Memorandum

To: Project File/28 Vannah Ave/129 F011
From: Mike Nugent/ Manager of Inspection Services
Date: 02/01/2002
Re: Egress Window/28 Vannah Ave. Basement Apartment

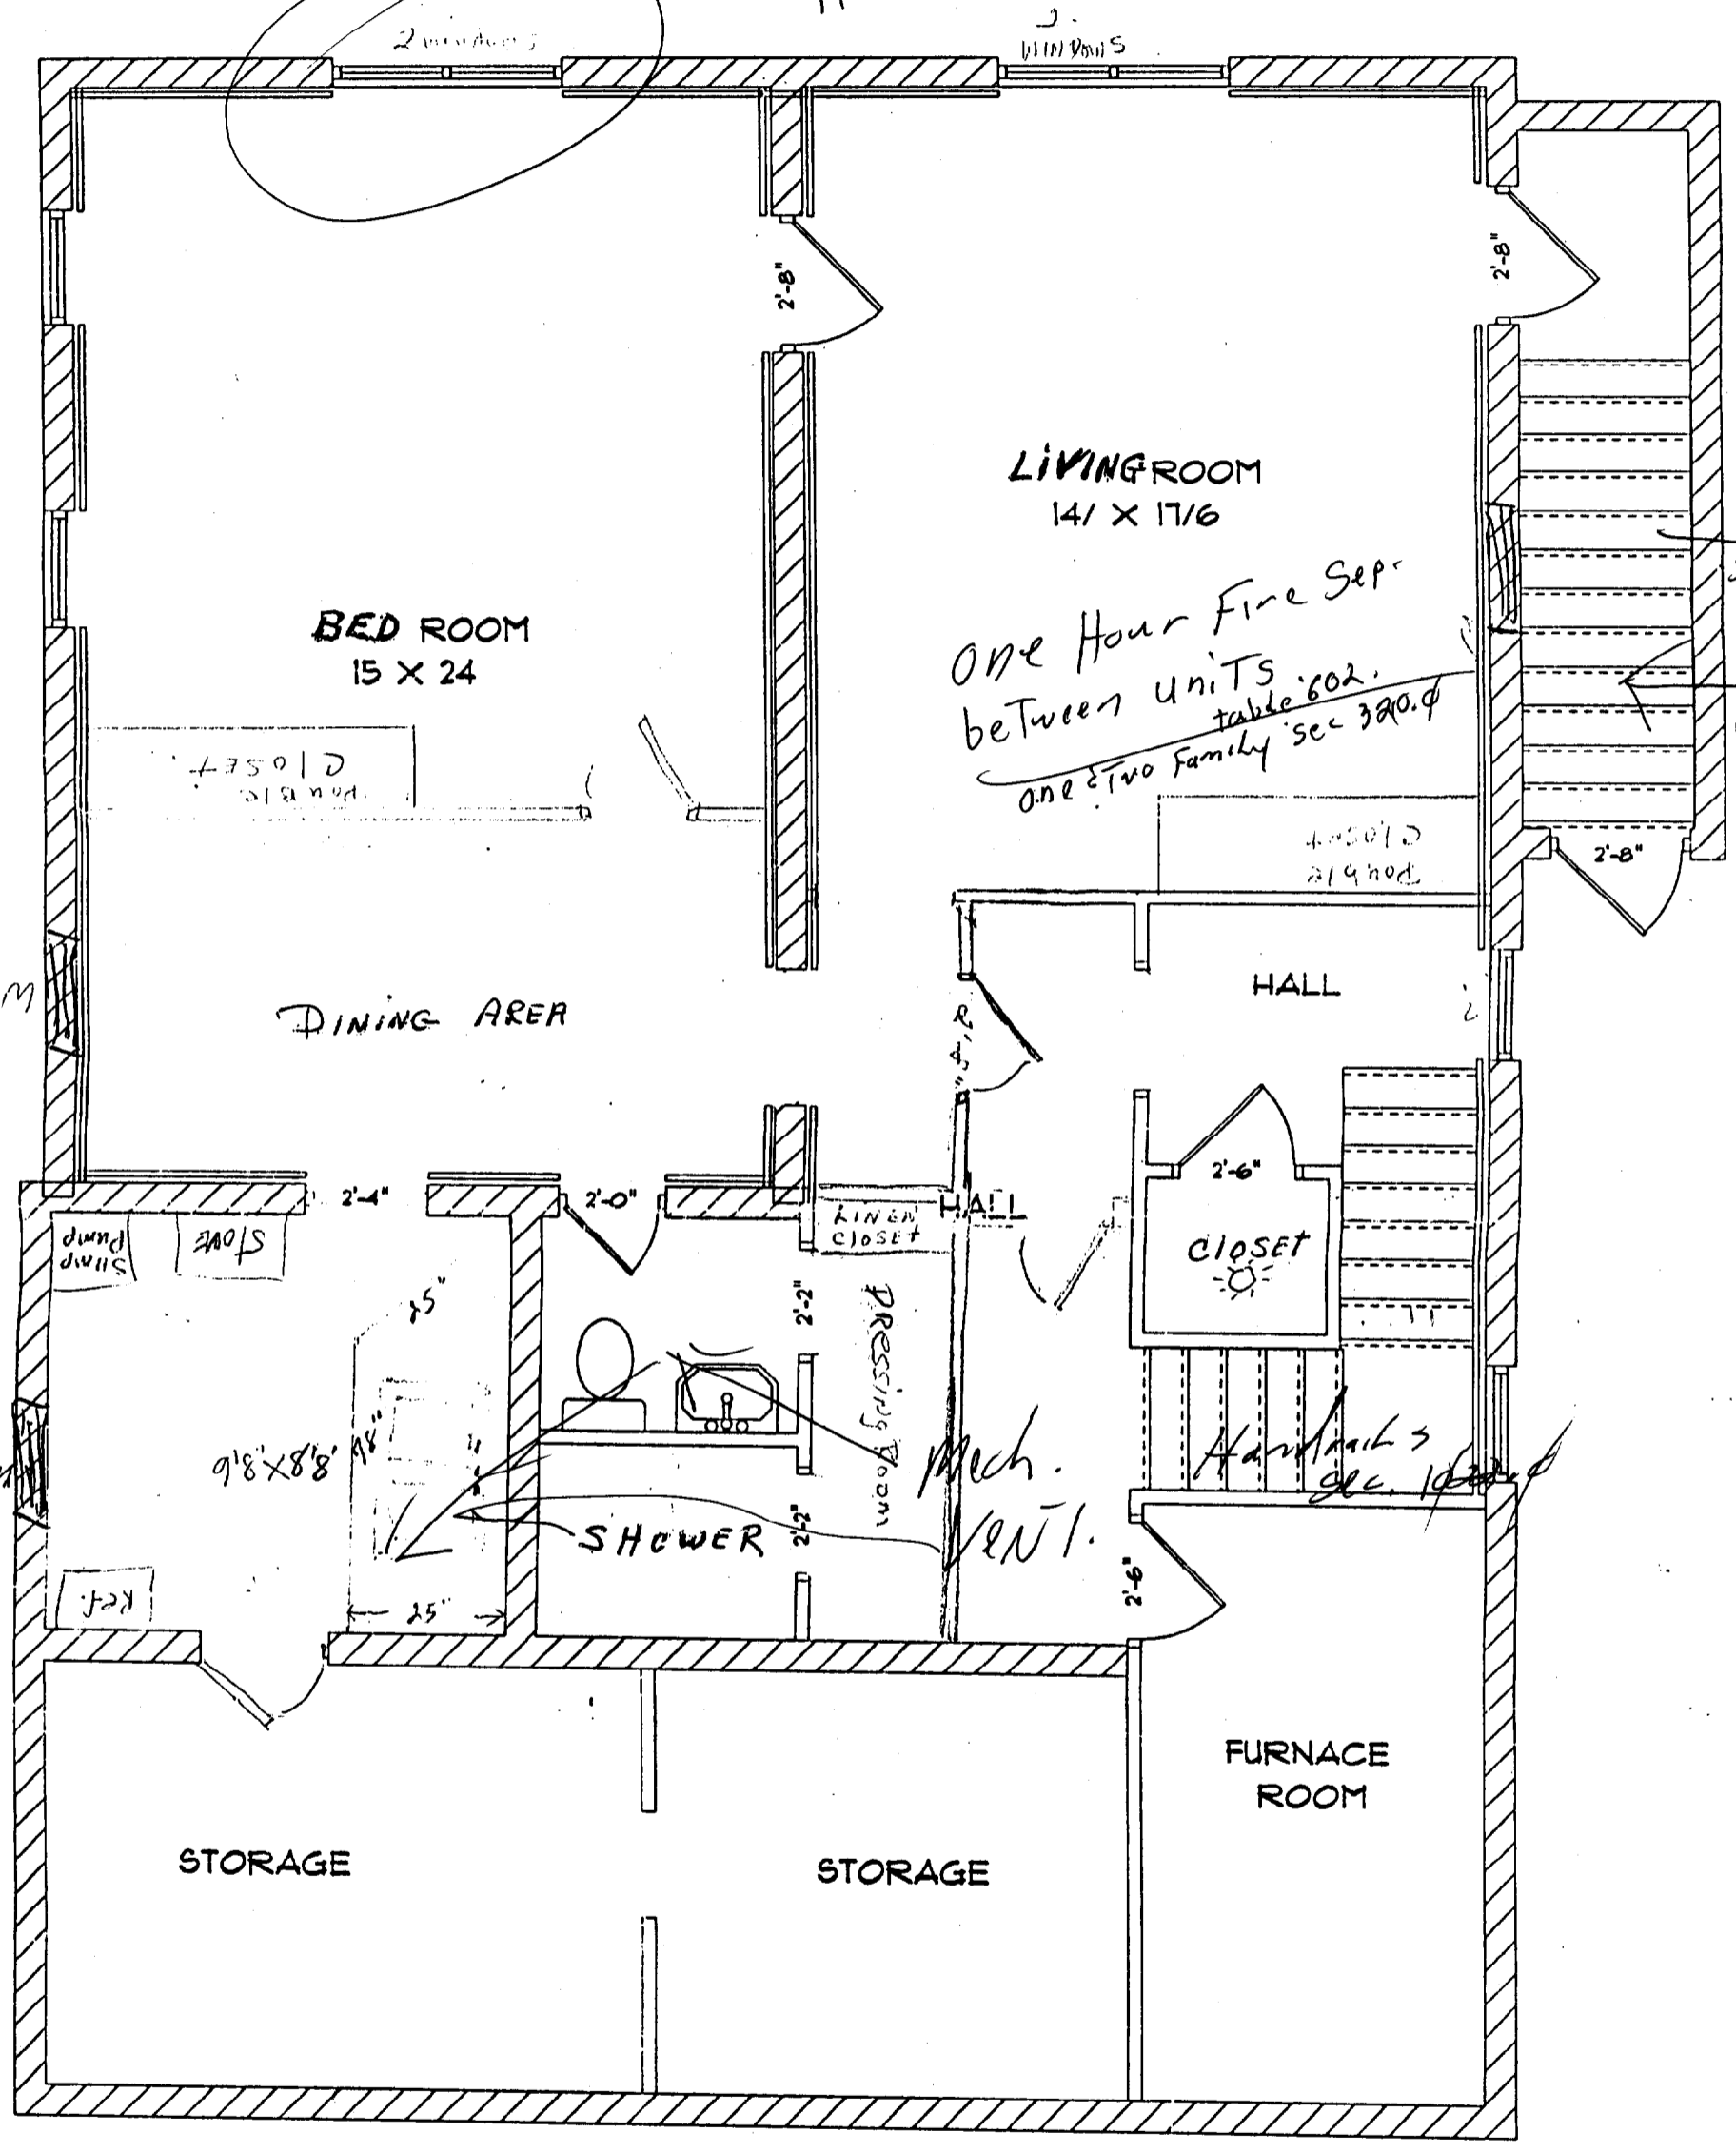
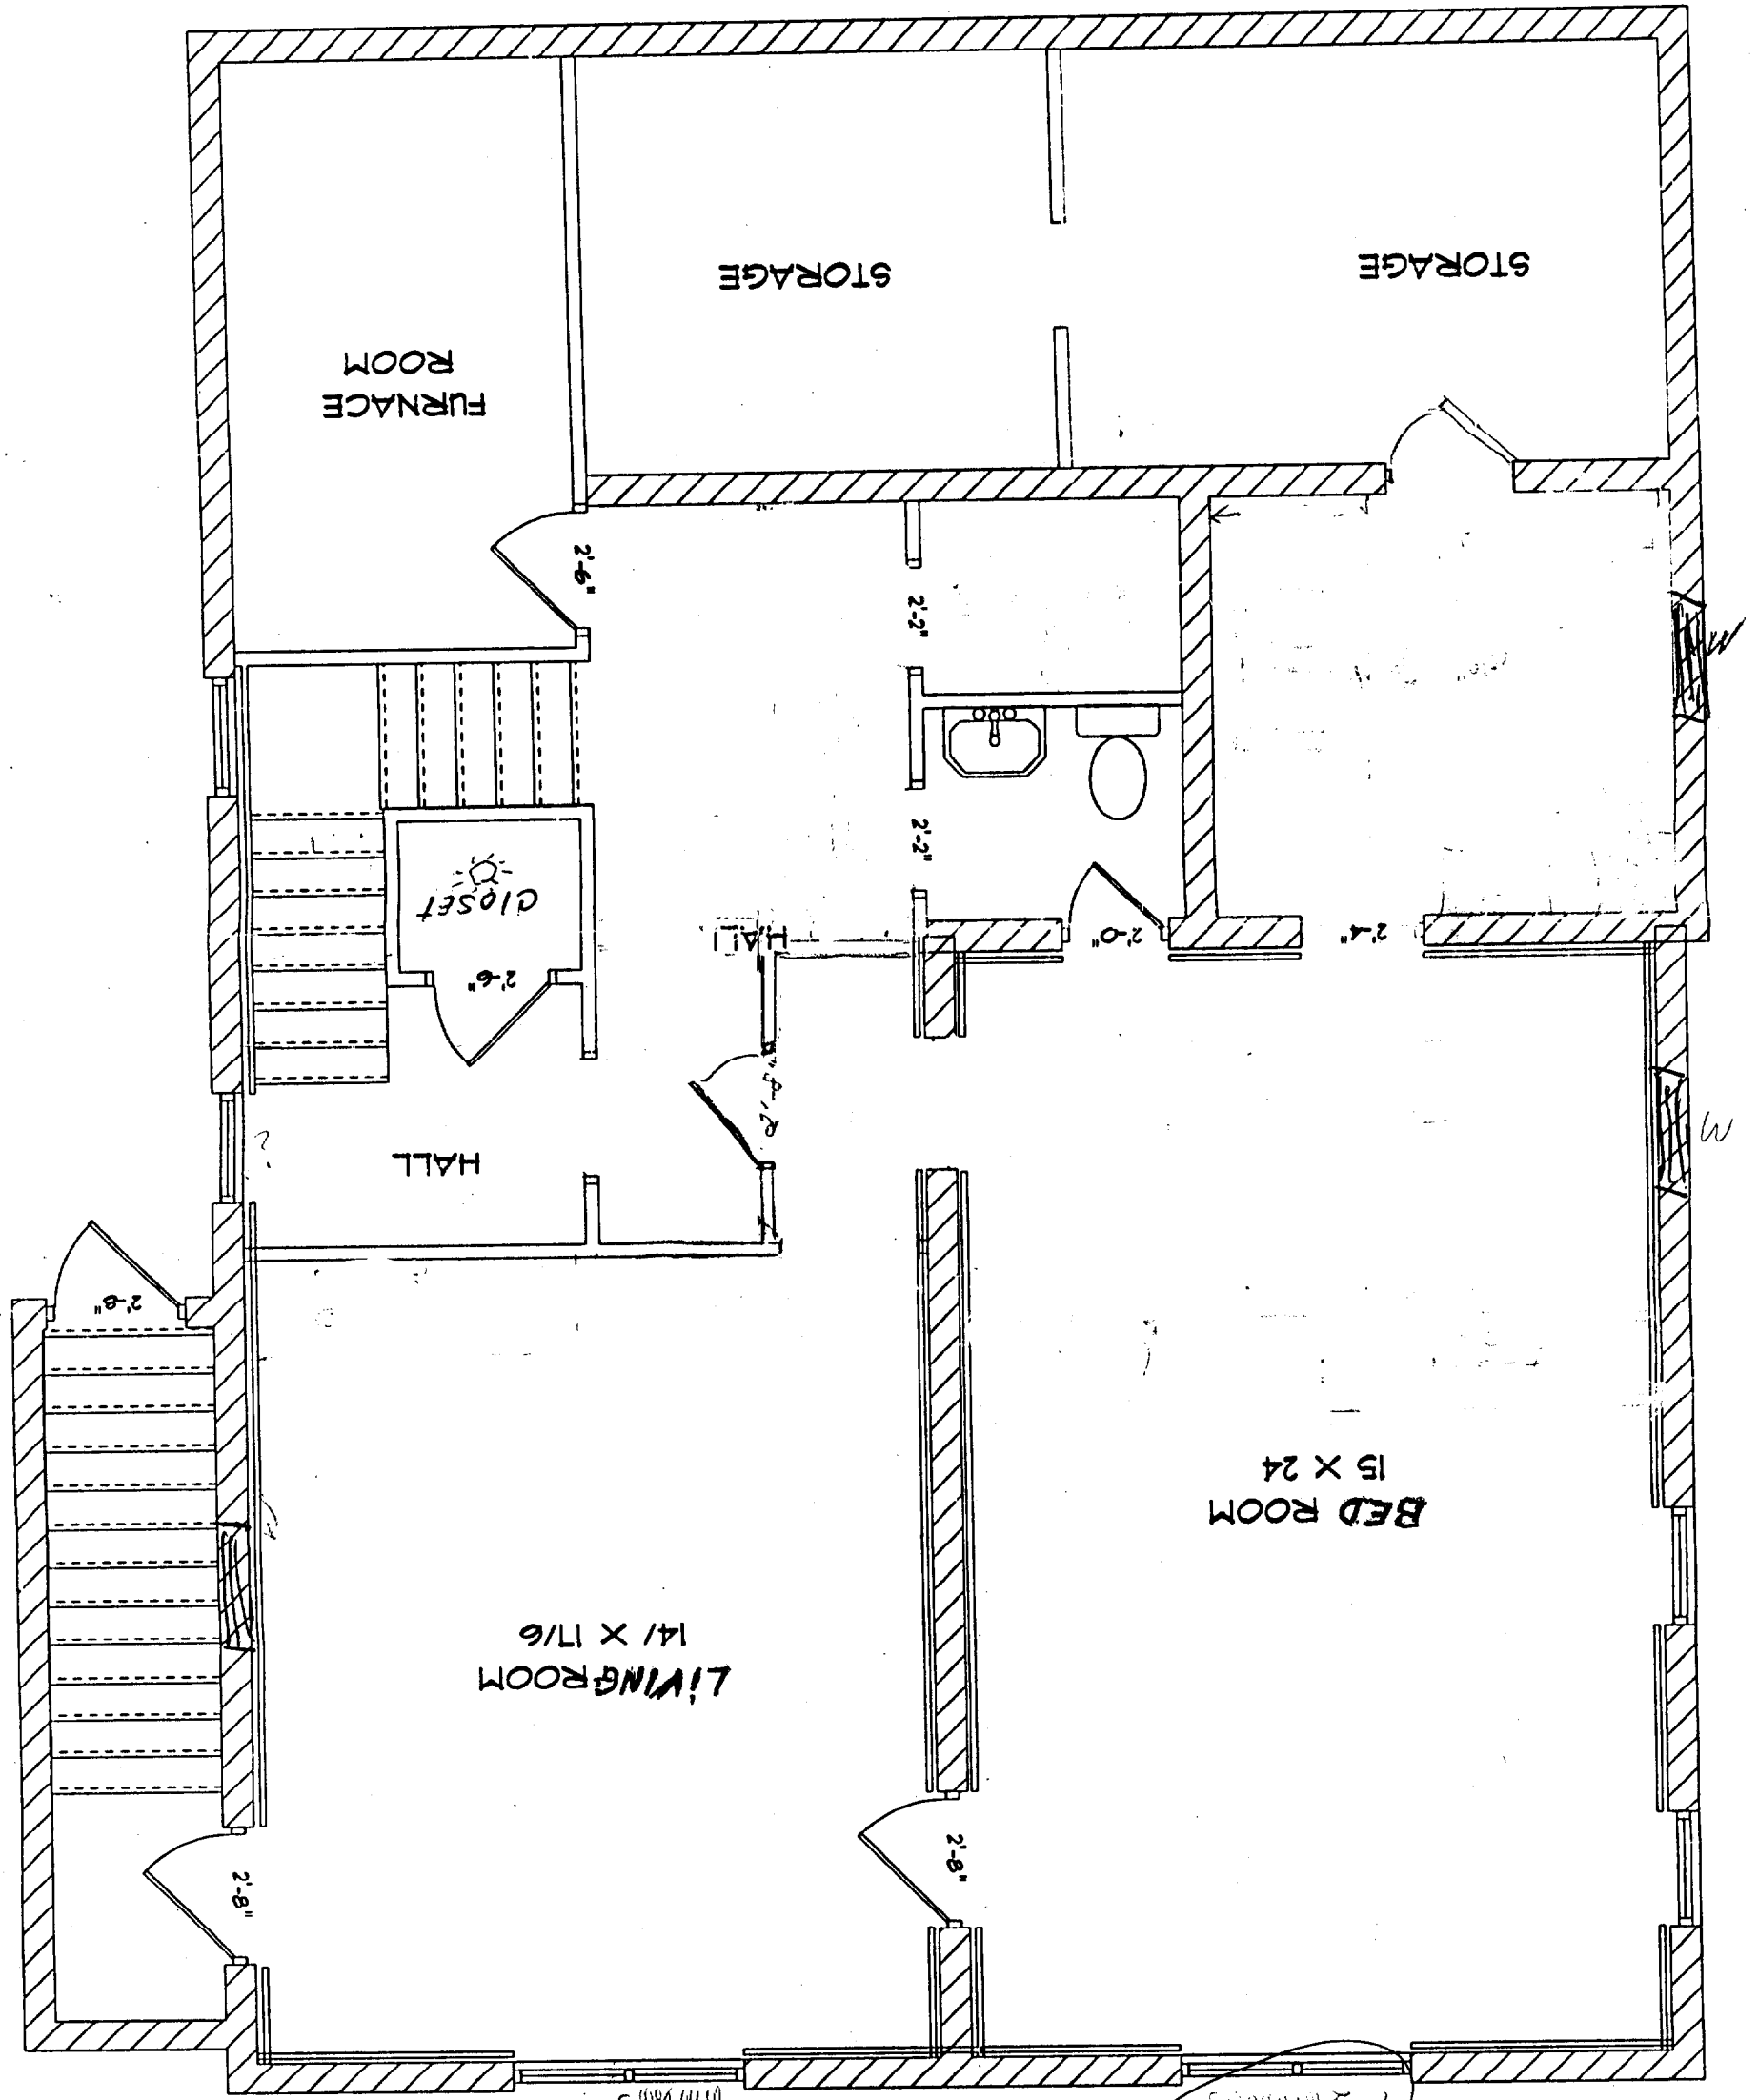
Attached is the platform, egress window and handrails plan for the interior emergency escape, Pursuant to Section 121.1 of the Building Code, the head room can be reduced to accommodate the emergency escape and the stair and landing width can be reduced to 30 inches. All other elements must comply with all applicable sections of the code.
